Reply To: address as below
Reference: N6/2013/2219/FP
and N6/2014/1307/FP
Direct Tel: 01707 357512
Fax: 01707 357255
Email: s.smith@welhat.gov.uk

**Amendments to existing and proposed window and door openings
7 Densley Close, Welwyn Garden City**

I refer to your application seeking permission for a non material amendment in connection with the above.

Drawn By: DAMIEN Scale: 1:100 Date: APR 2013  
 City Status: PLANNING Checked:  
 Drawing No: 3018-P03 Revision: C

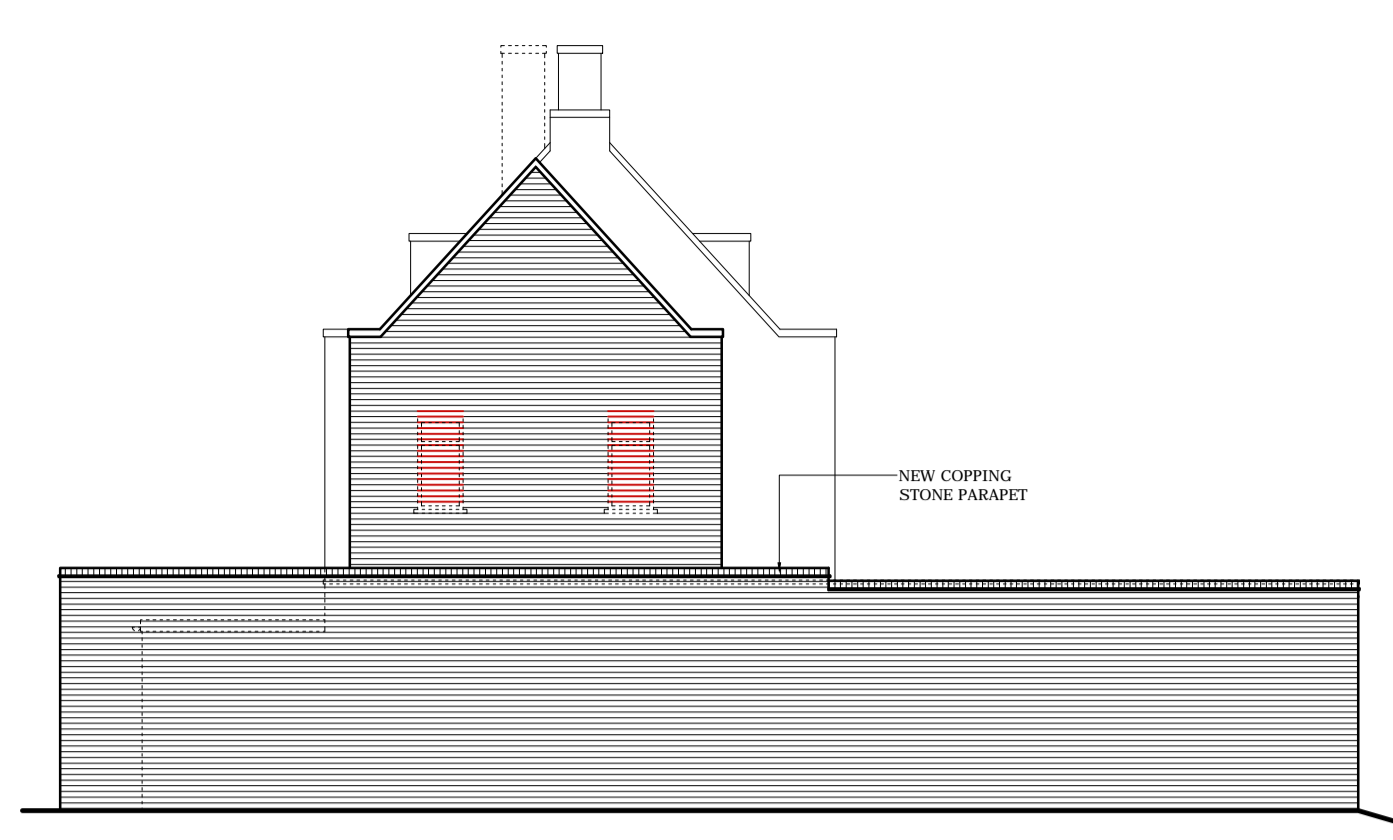
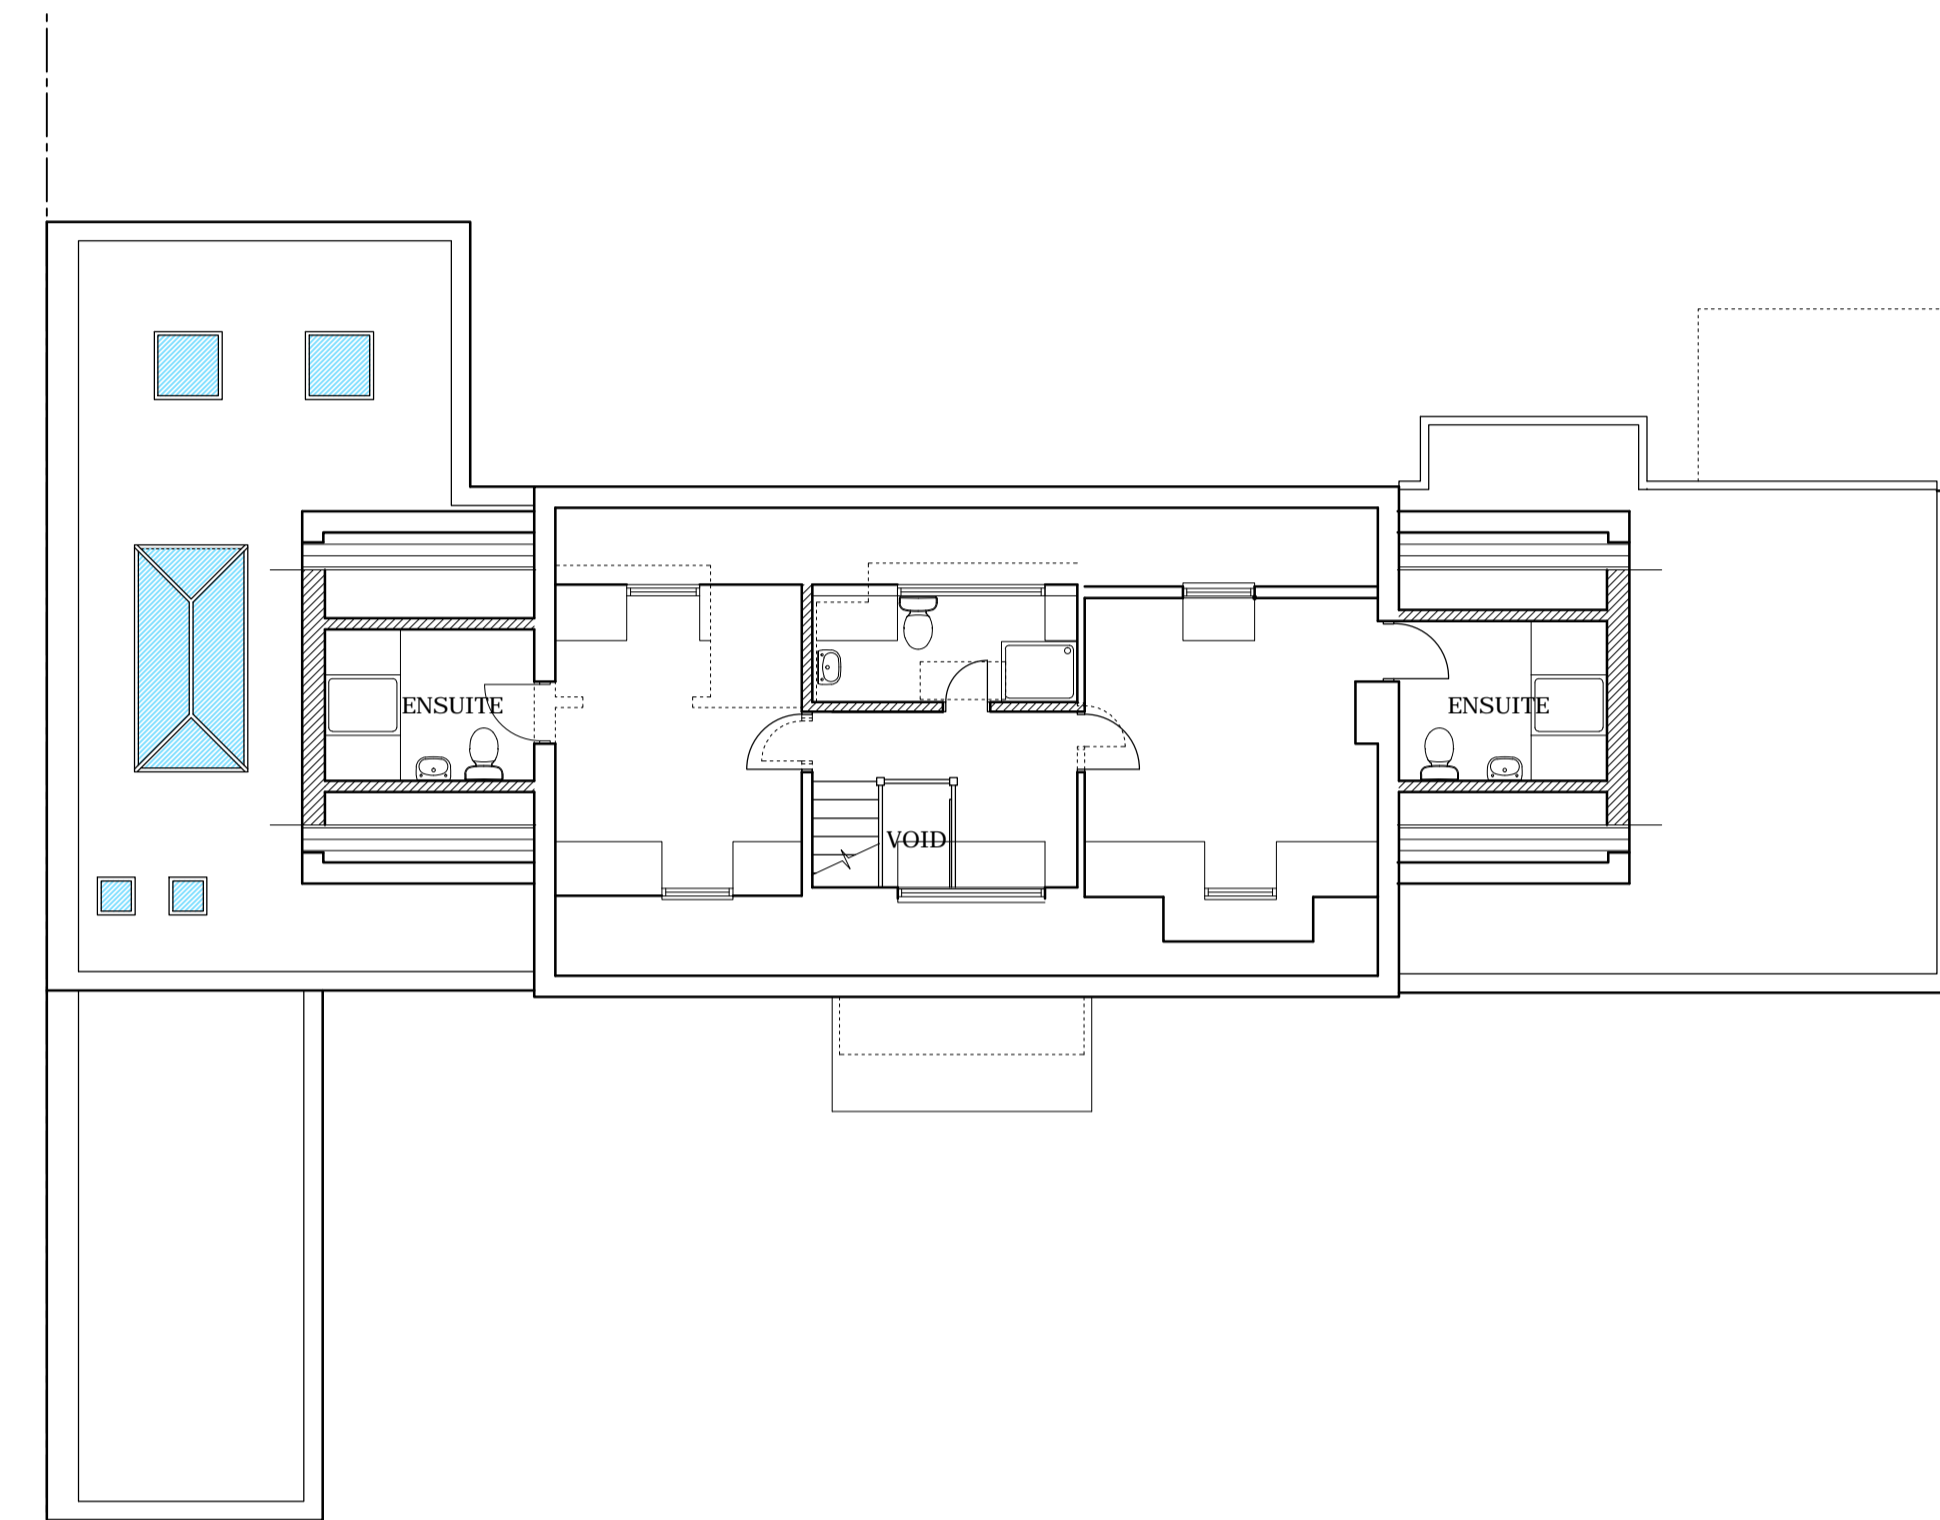
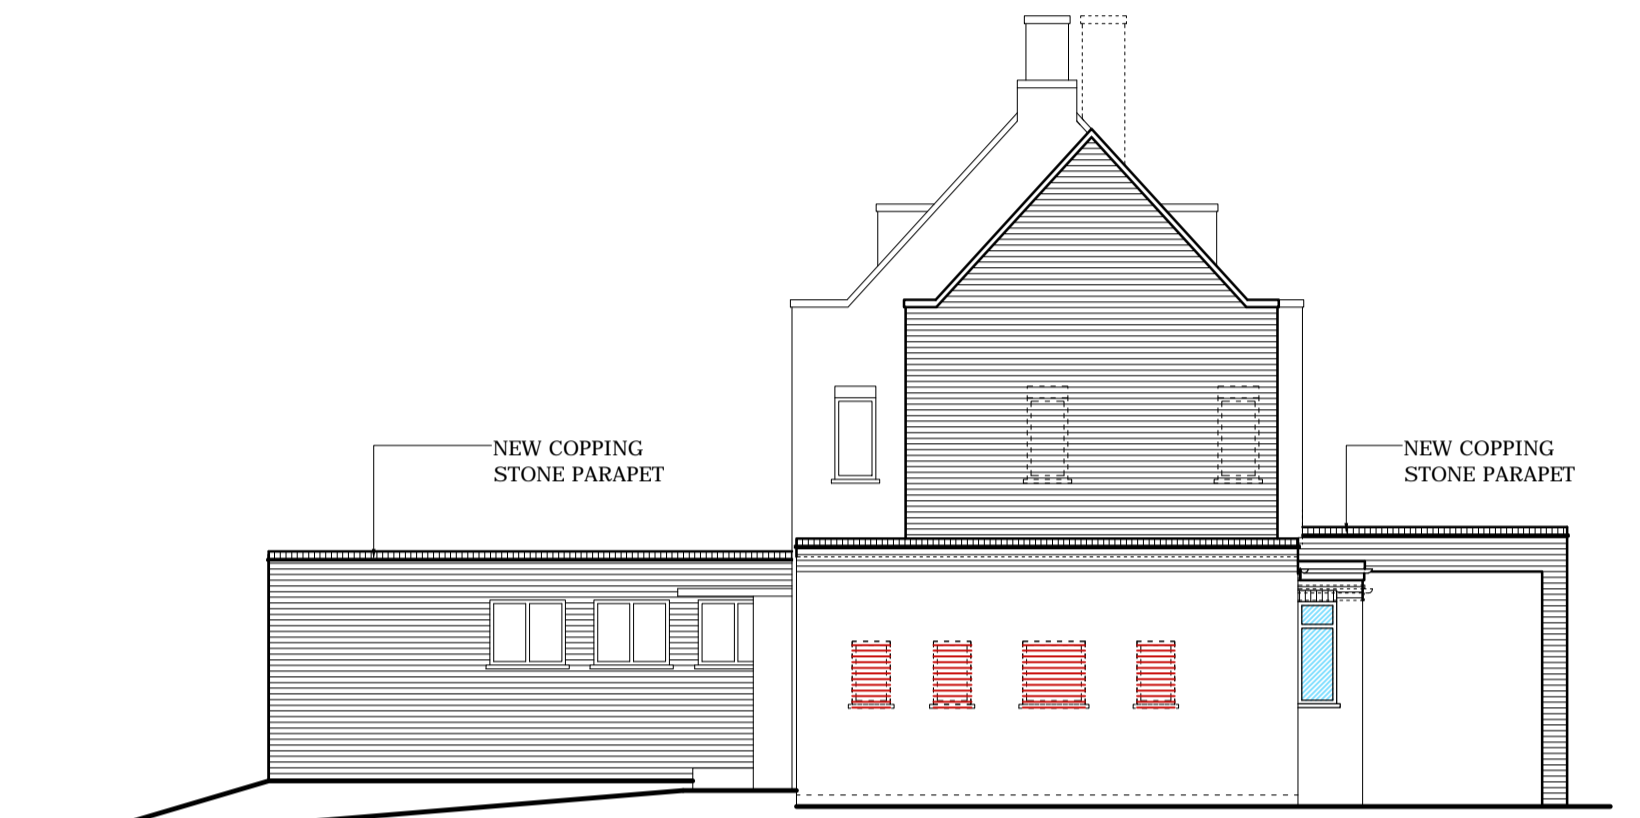
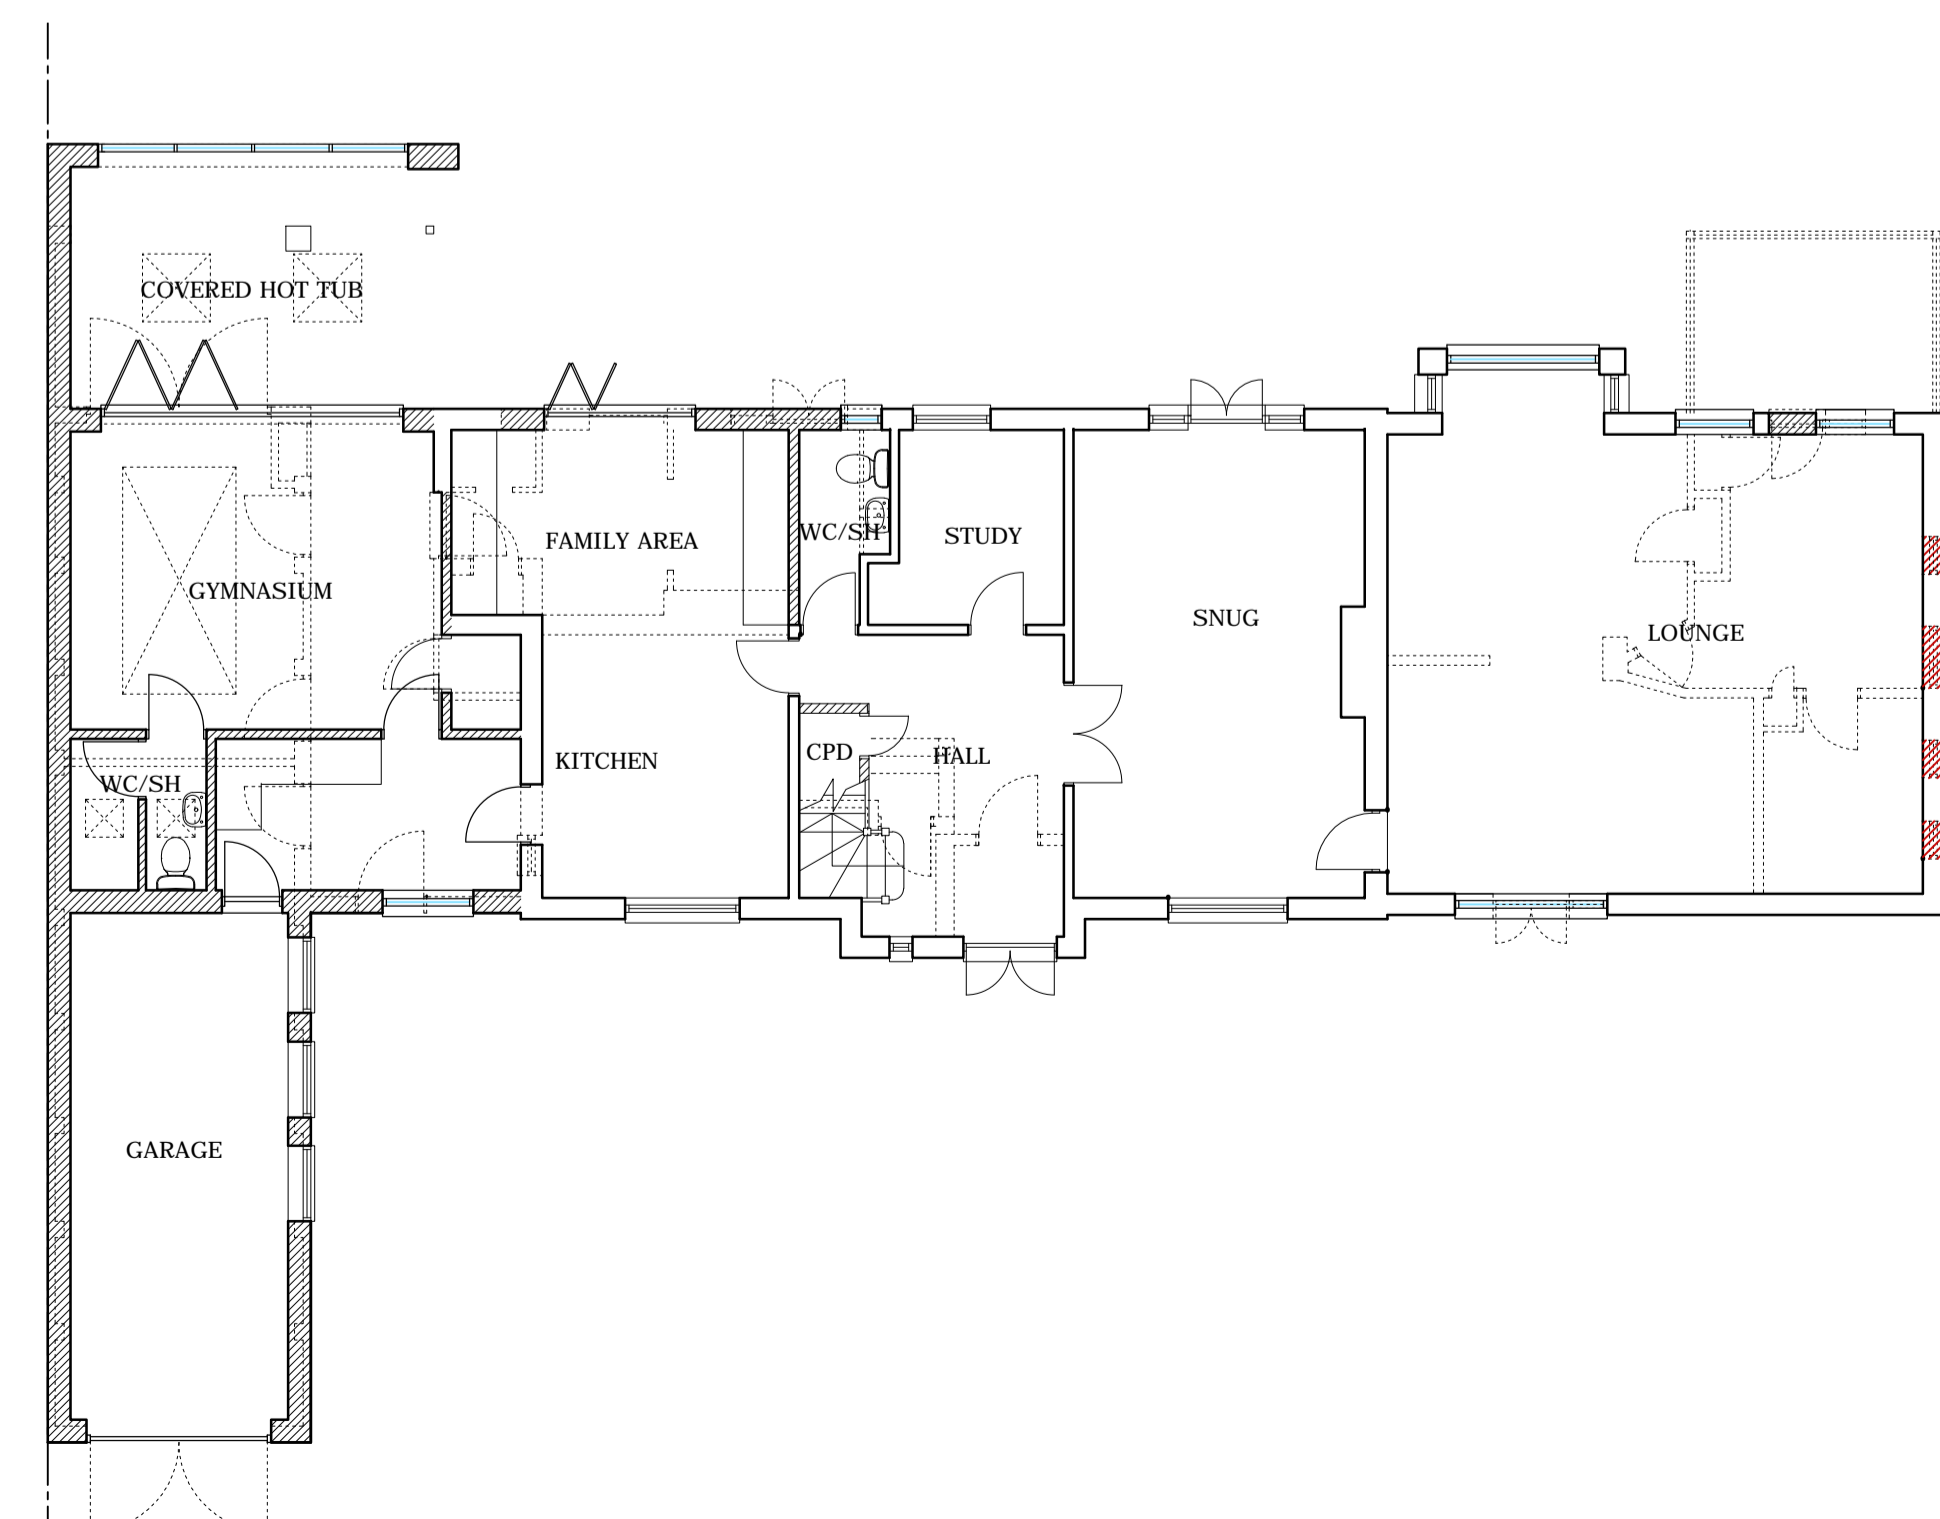
The amendments shown on the submitted drawings are considered to be a non-material amendment to the original planning permissions as the proposed changes are located within the existing property and the changes to the appearance of the property are not in my opinion significant and would not be materially different to that originally approved and the changes would not contravene any Planning Policy. Additionally the interests of any third party or body who participated in or were informed of the original decision would not be disadvantaged in anyway.

Accordingly, the Council considers the proposed amendments to be non material and acceptable. Those approved changes are to the fenestration only as listed above and for no other aspects of the approved scheme. The approved amendments are shown on Drawing No. 3018-P03 Rev C received and dated 12 May 2016.
